Your Ref	SSD-49808717
Our Ref	NCA/21/2022
Contact	Paul Sartor
Telephone	9806 5740
Email	psartor@cityofparramatta.nsw.gov.au

27 July 2023

**COUNCIL SUBMISSION
NOTICE OF EXHIBITION OF ENVIRONMENTAL IMPACT STATEMENT FOR THE
FITZWILLIAM AND ARGYLE STREETS BUILD-TO-RENT AND OFFICE TOWERS (2 AND
2R FITZWILLIAM ST, PARRAMATTA)**

Massing Envelope

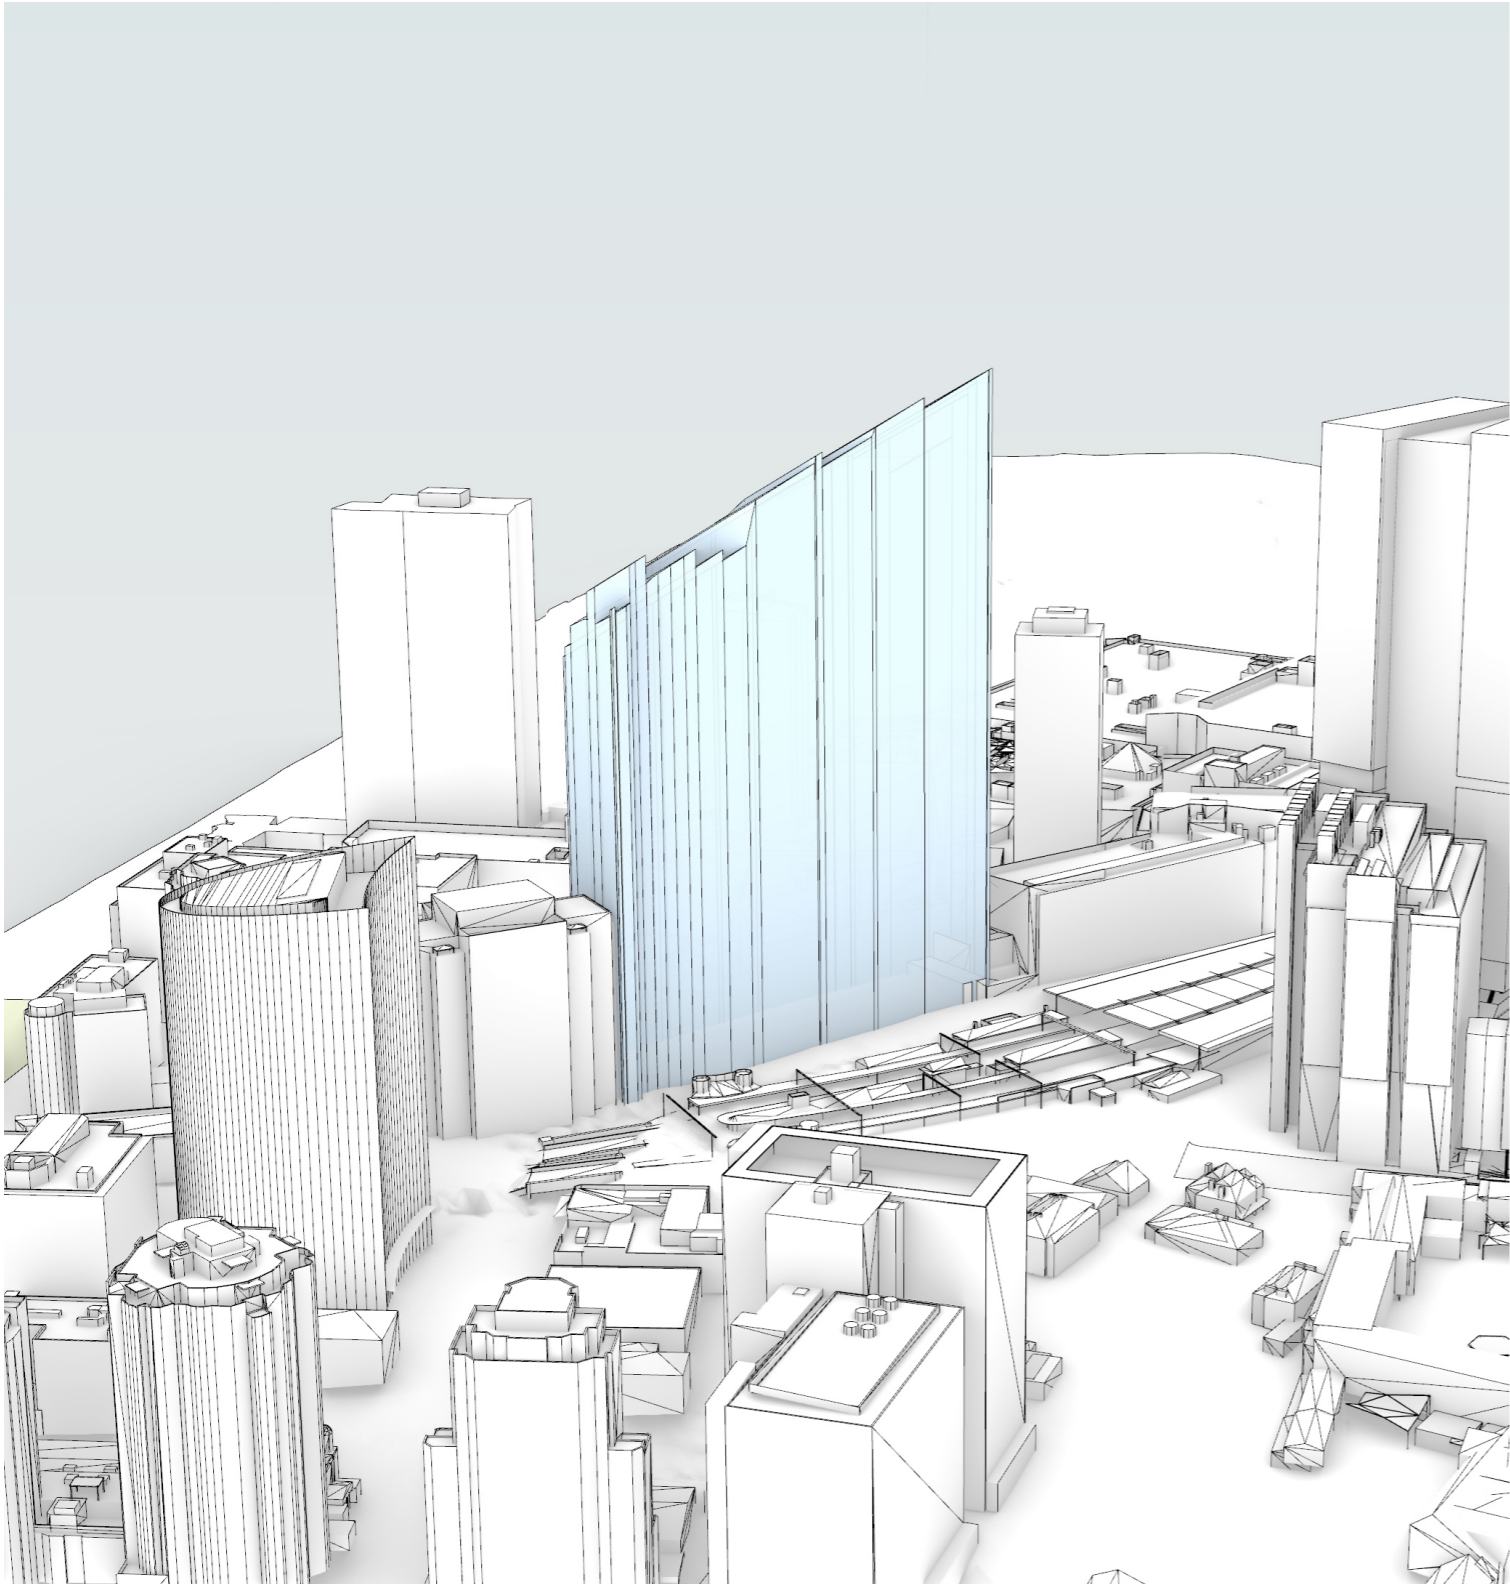
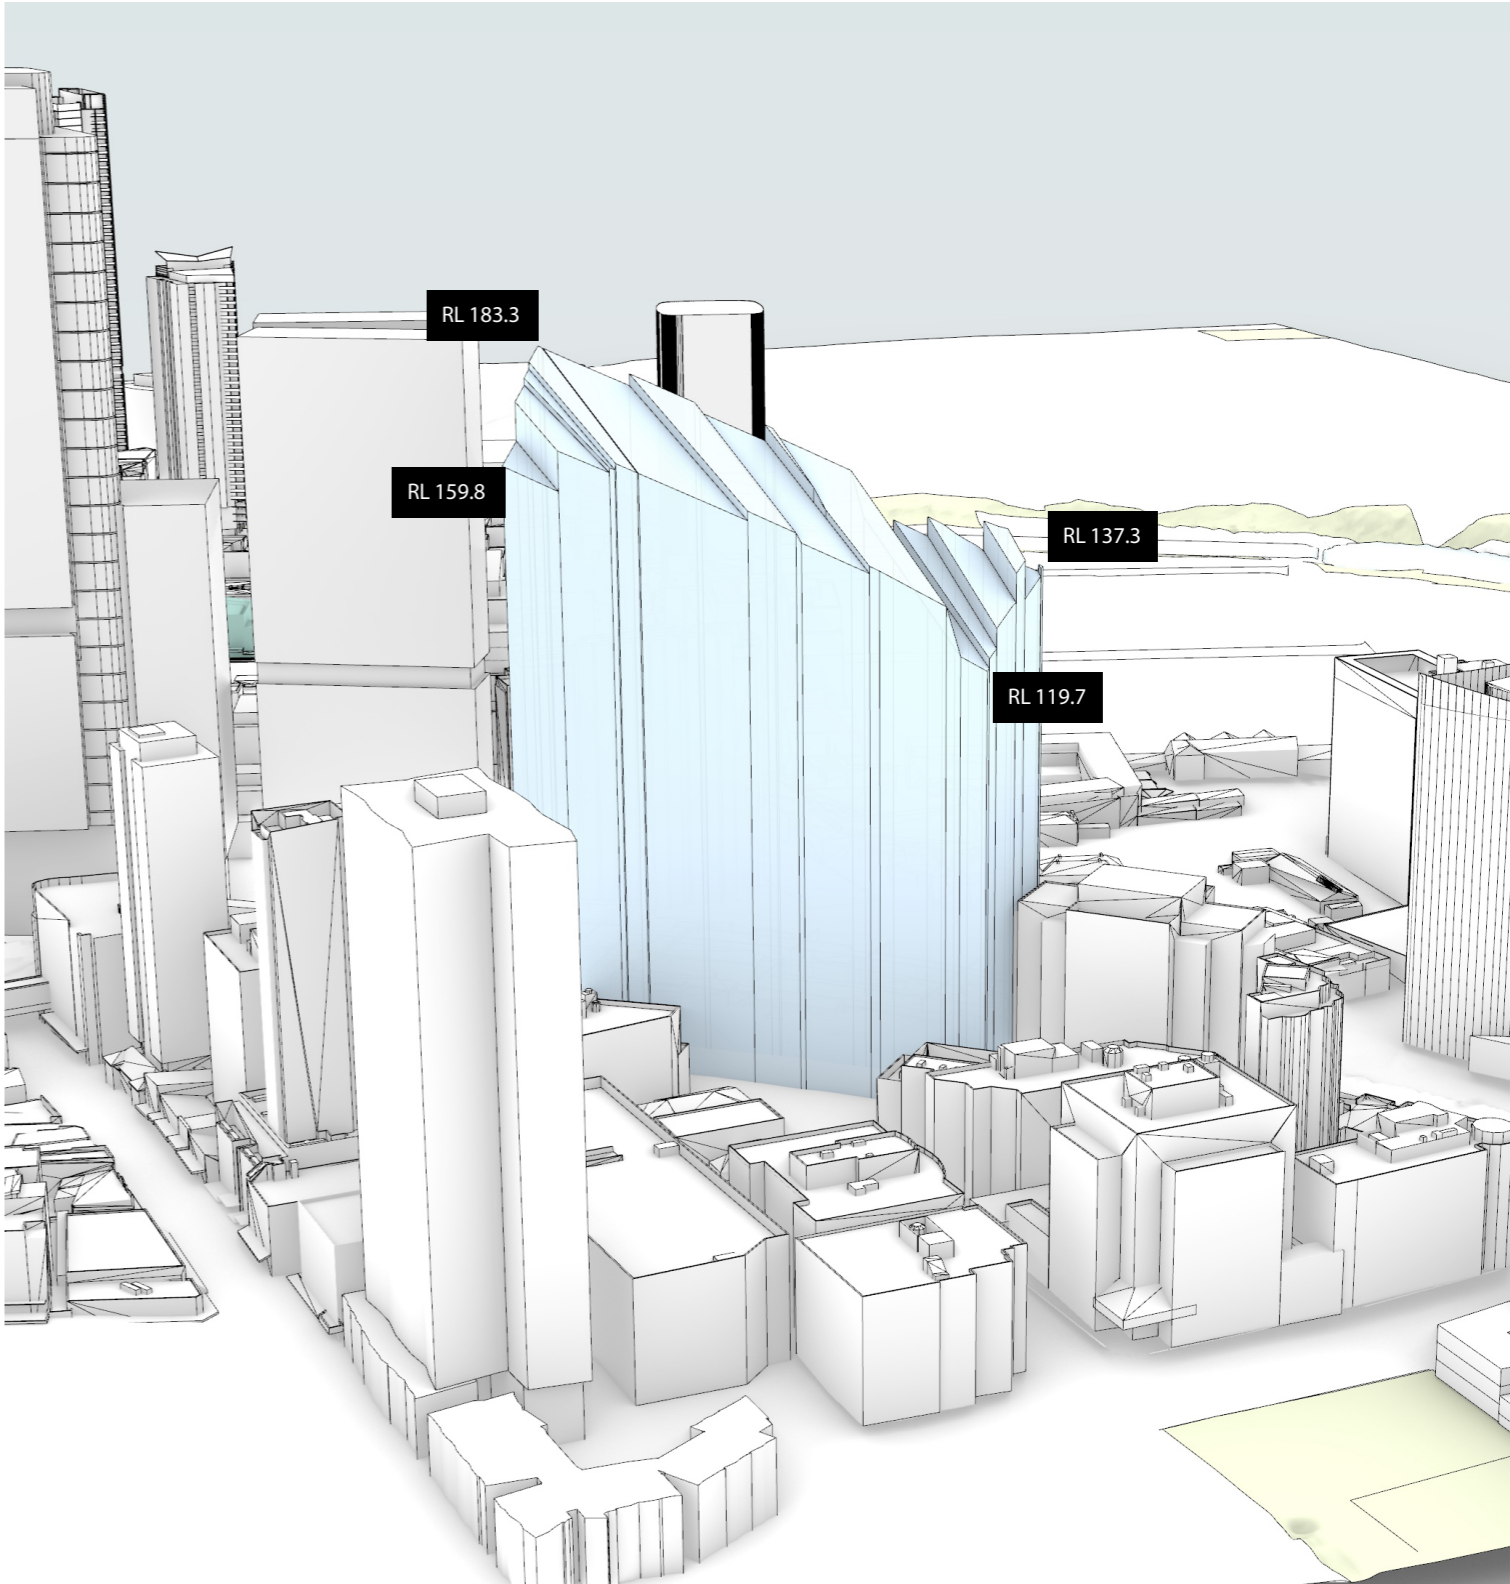
The proposal's bulk, massing and modulation is excessive. Greater podium height, tower separation and setbacks are to be provided for the development to better comply with the PDCP 2011 and achieve an improved built form outcome as detailed in this submission. Under 6.13 of PLEP 2023 to meet the Design Excellence requirements, the application would be assessed against the controls contained within part 6 of PDCP 2011.

Given the age of the Westfield Cinema building it should not be used as a precedent. It is recommended that the proposed podium retains a maximum height of 21m as per the DCP. This street wall will still relate to the 24m height of the existing Westfield building while ensuring a consistency to the street wall for future development.

PDCP 2011 recommends a minimum 6m tower setback from podiums. A nil tower setback to Argyle Street and Fitzwilliam Street is not supported as it does not result in a distinct street wall with a defined human-scale and increases the perceived scale of the development from the ground level. Recognising that the site is constrained in terms of depth, it may not be possible to achieve the full setback requirement. Notwithstanding, the setback adopted must be sufficiently justified and ensure the relevant PDCP 2011 objectives are met.

Typical Floor Plan - levels 5 to 38

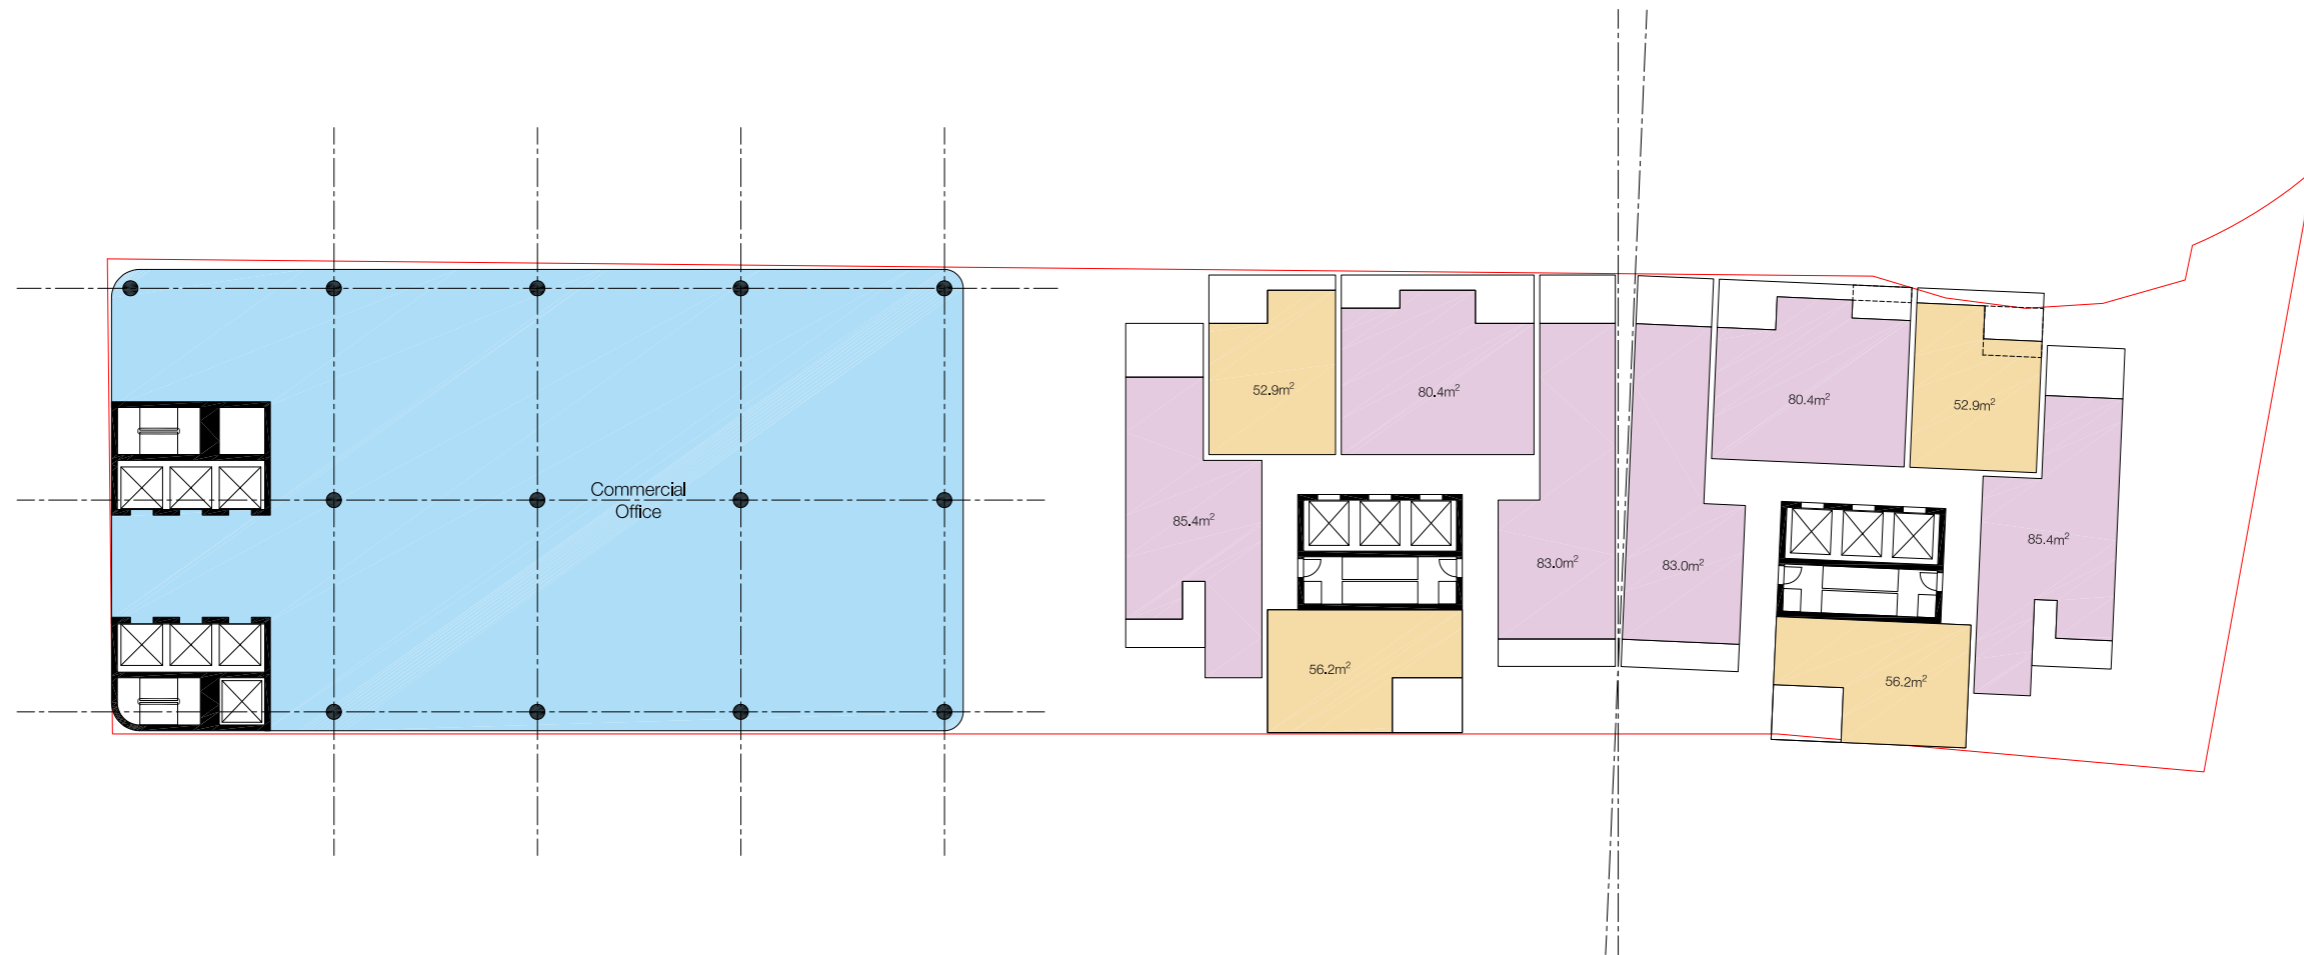
The proposed 12m separation between the two towers is inadequate. While mitigation of some privacy issues has been considered in the concept scheme, there is little consideration

of the impacts that reduced tower separation may have on the amenity of streets and public spaces. Providing adequate daylight and sky views and breaks between buildings large enough to reduce the overall impact of cumulative increased density within the city is imperative. It is evident in the view analysis that the proposed 12m tower separation does not provide substantial separation as three of the four views show the towers as one uninterrupted mass.

Part 6 of the PDCP 2011 requires a minimum 15m building separation above street wall height for commercial buildings seeking to benefit from the unlimited floor space provision in Clause 7.28 of the PLEP 2023. As such, it is required that the building separation between the two towers be increased to a minimum 15m.

The 6m tower setbacks to the north and south must both increase to 7.5m (from the boundary) to comply with the 15m building separation requirement associated with this clause. A 7.5m setback from the boundary will ensure adequate breaks between towers should the adjoining sites develop and prevent the onus of this separation being unevenly allocated to neighbouring sites. A 7.5m setback to the north boundary would be contingent on meeting the requirements of the ADG for privacy with increases up to 12m as per the ADG requirements.
